| Application number: 2024/93544   |                                                |
| What is the application for?:    | Erection of 2 garden pods                      |
| Address of the site or building: | 3D, Broad Lane, Upperthong, Holmfirth, HD9 3JS |

Drawing Title/Issue
 Proposed Block Plan

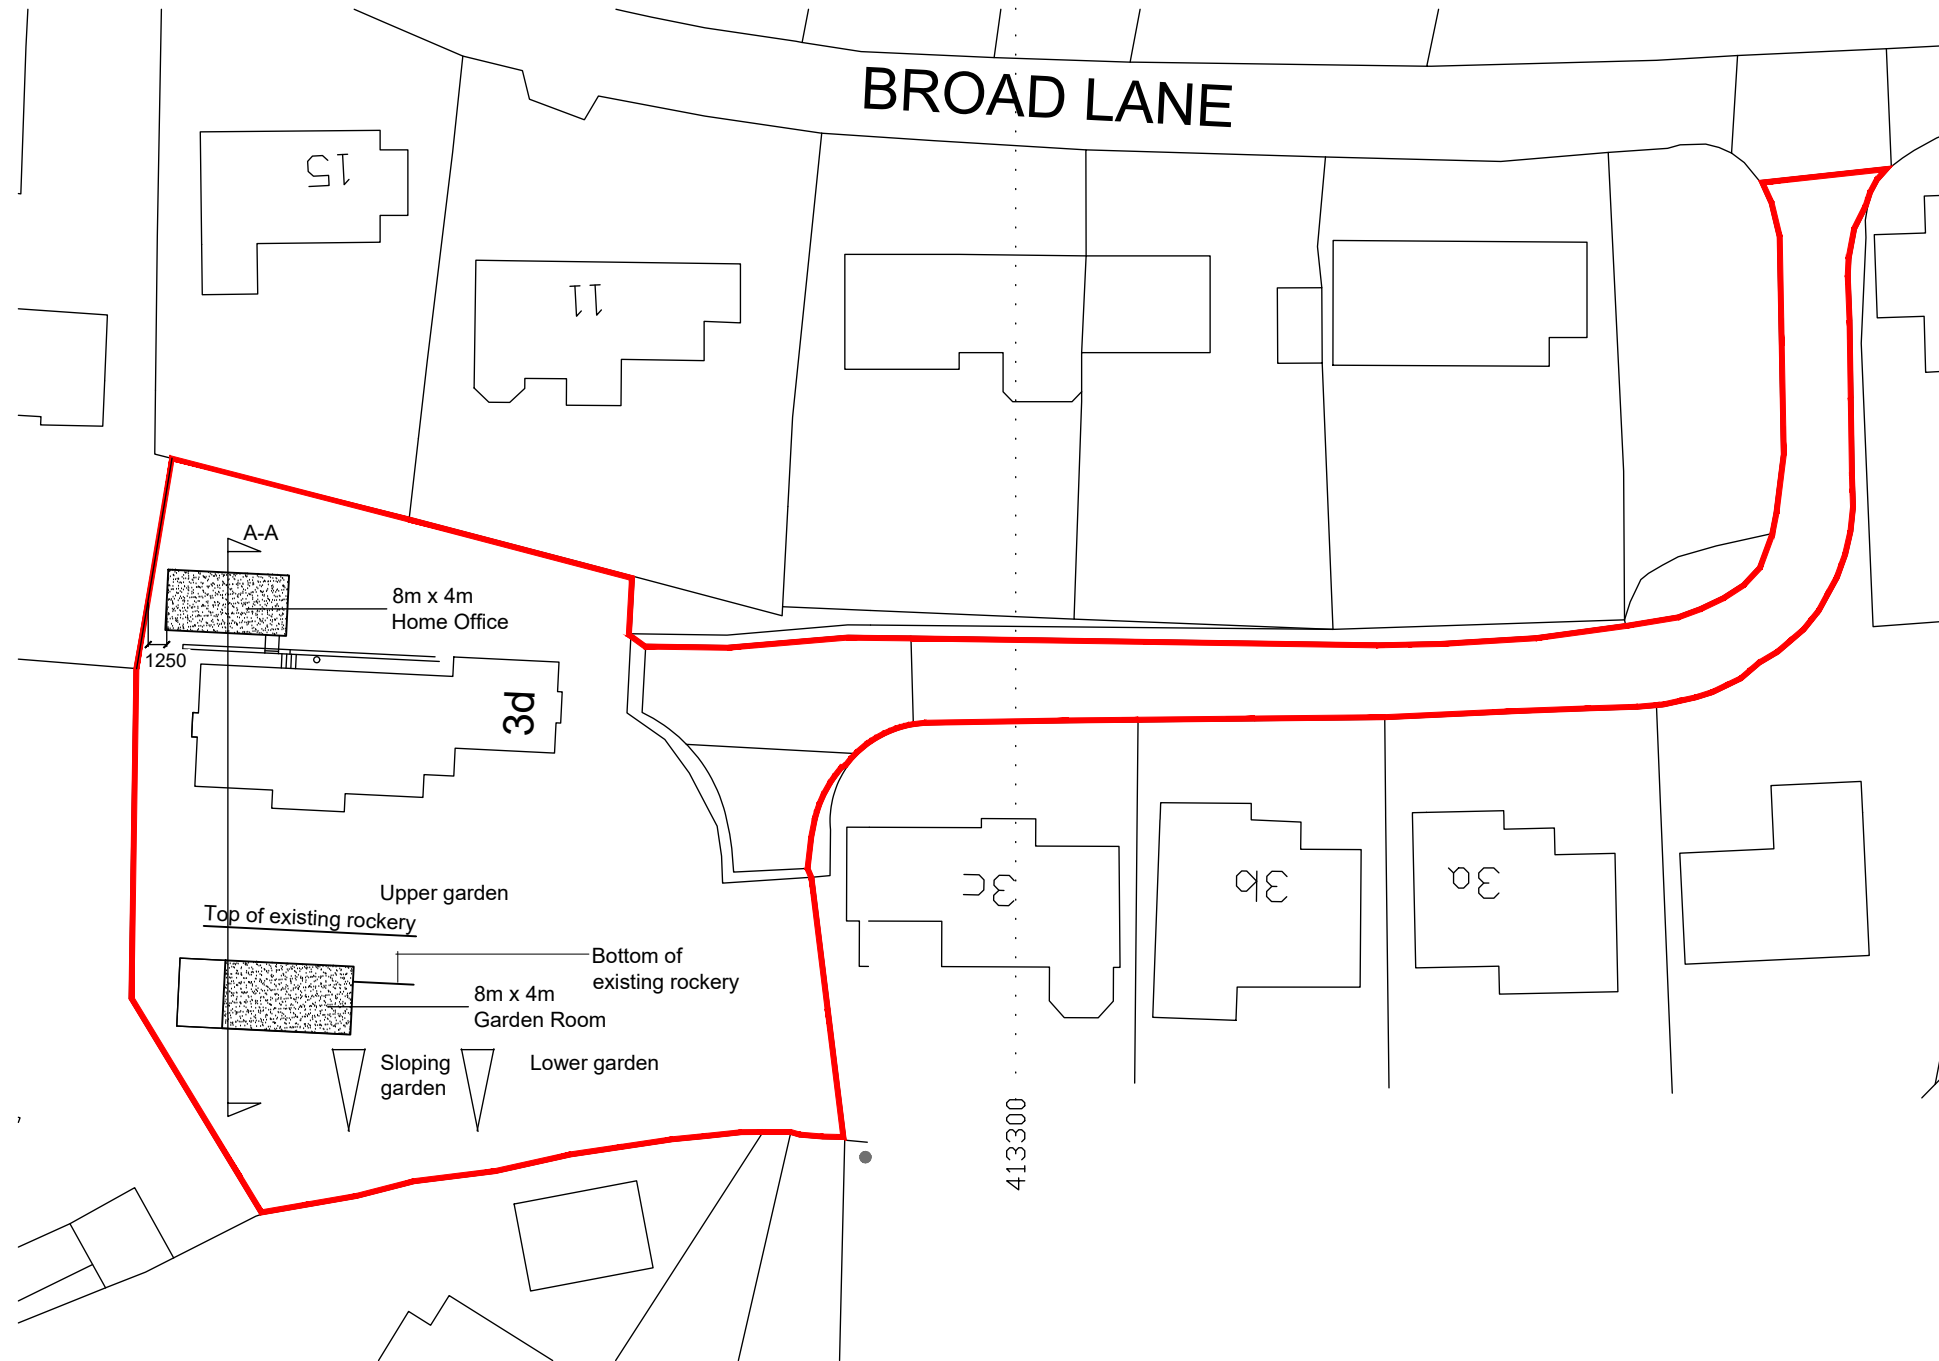
| <p>The original planning application for the construction of 3D Broad Lane (2015/93021) raised concerns regarding flood management on site. This was dealt with for the footprint of the house but there would appear to be water courses where the Garden Pod is to be sited. As we have had to have costly remedial work due to watercourses being diverted during extensions to a house on Broad Lane on our Northerly boundary, is there any possibility this will occur due to the proximity of the Pod and watercourses to our Westerly boundary.</p> <p>The plans for the Garden Pod show large side windows, a large patio and Barbecue, toilet and kitchen near to our boundary, obviously designed for partying. Having experience of an AIRBNB in a much smaller property two doors away from us on Greenfield Road - Stag and Hen Parties, noise from late night taxis etc, the possibility of this property being used for business purposes would be totally unacceptable. Unless we can be given assurances on the two points above, we object to the planning application.</p> |     |
